CITY OF ALBUQUERQUE

**Re: Raising Cane's 2004 Wyoming Blvd. NE
Traffic Impact Analysis
HT#H20D032A
Engineering Seal date 10/7/2021**

Review of the Raising Cane's 2004 Wyoming Blvd. NE Traffic Impact Analysis (TIA), dated 10/7/2021, received February 15, 2022 has been completed by the City's Planning Transportation Development section. The following comments should be addressed prior to the next submittal.

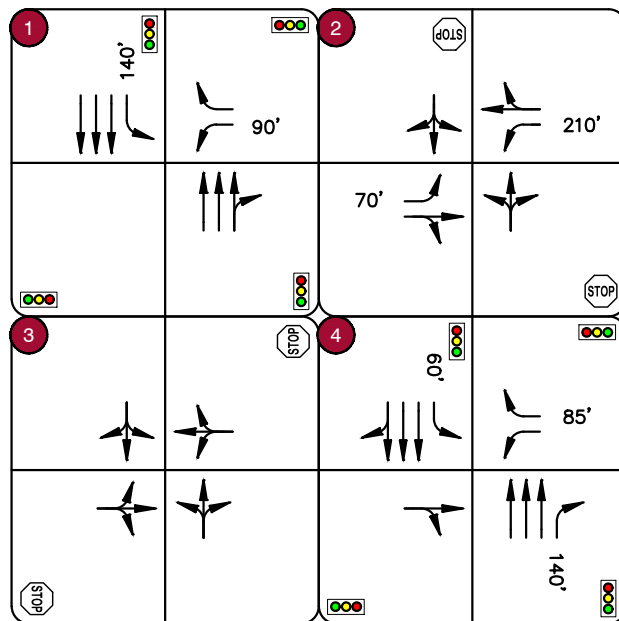
5. The posted speed limit image in figure 3 shows the speed limit on Northeastern Blvd. as 40 MPH. The posted speed limit is 30 MPH on Northeastern Blvd. The report text has the correct speed limit. Correct the speed limit sign image in figure 3.

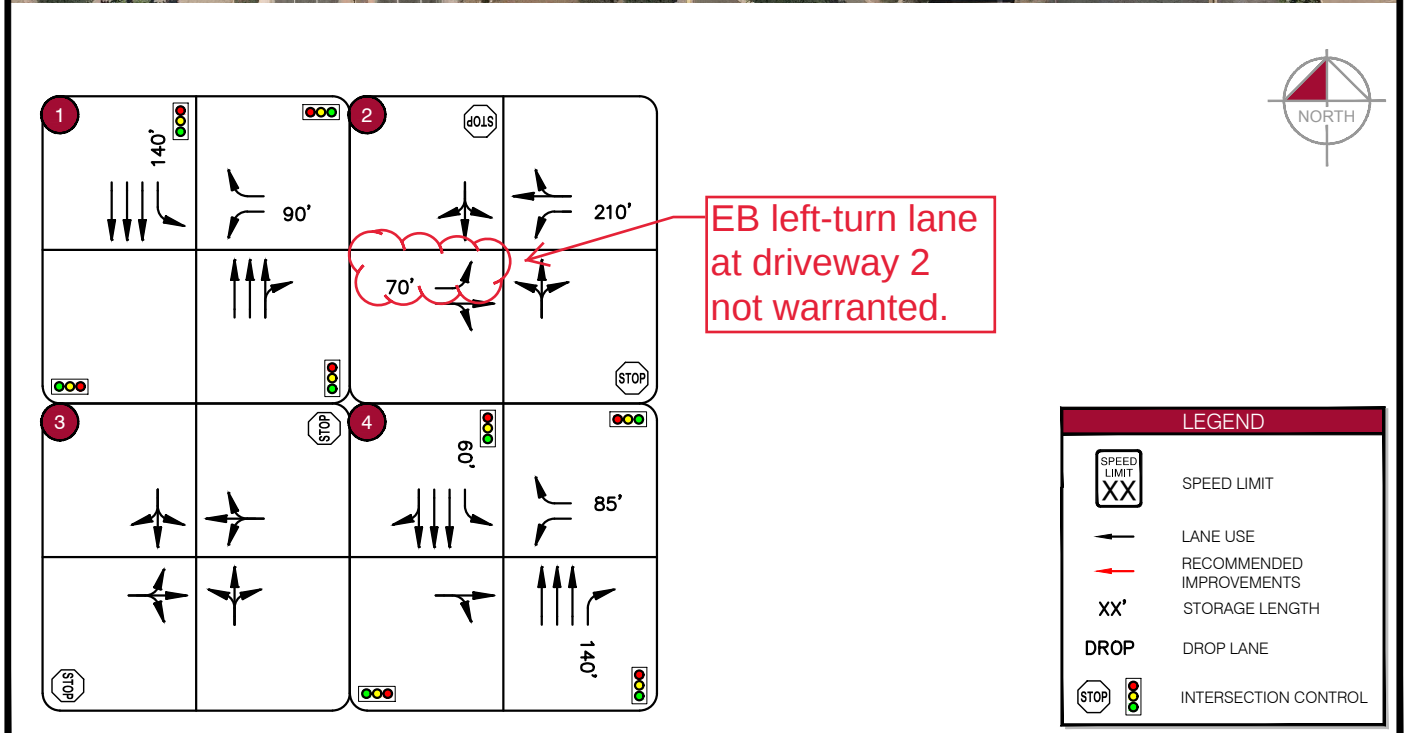
1. Increase the westbound left-turn lane storage length on Northeastern Blvd. approaching Wyoming Blvd, Intersection #1.
2. Remove the eastbound left-turn lane on Northeastern Blvd. at Driveway A, Intersection #2. This turn lane may be removed because the peak hour turning volumes are less than required for a left-turn lane for all studied scenarios. Removal of this lane will provide the space needed to lengthen the westbound left-turn lane at Wyoming Blvd.

3. Intersection #2 where Driveway A intersect Northeastern Blvd. the left and right turning movement volumes exceed the threshold for turn lanes. This intersection should be re-stripped as a 3-lane section with a southbound right-turn lane, southbound left-turn lane and one northbound driving lane. Intersection lane control signs, R3-8 series type, should be included.
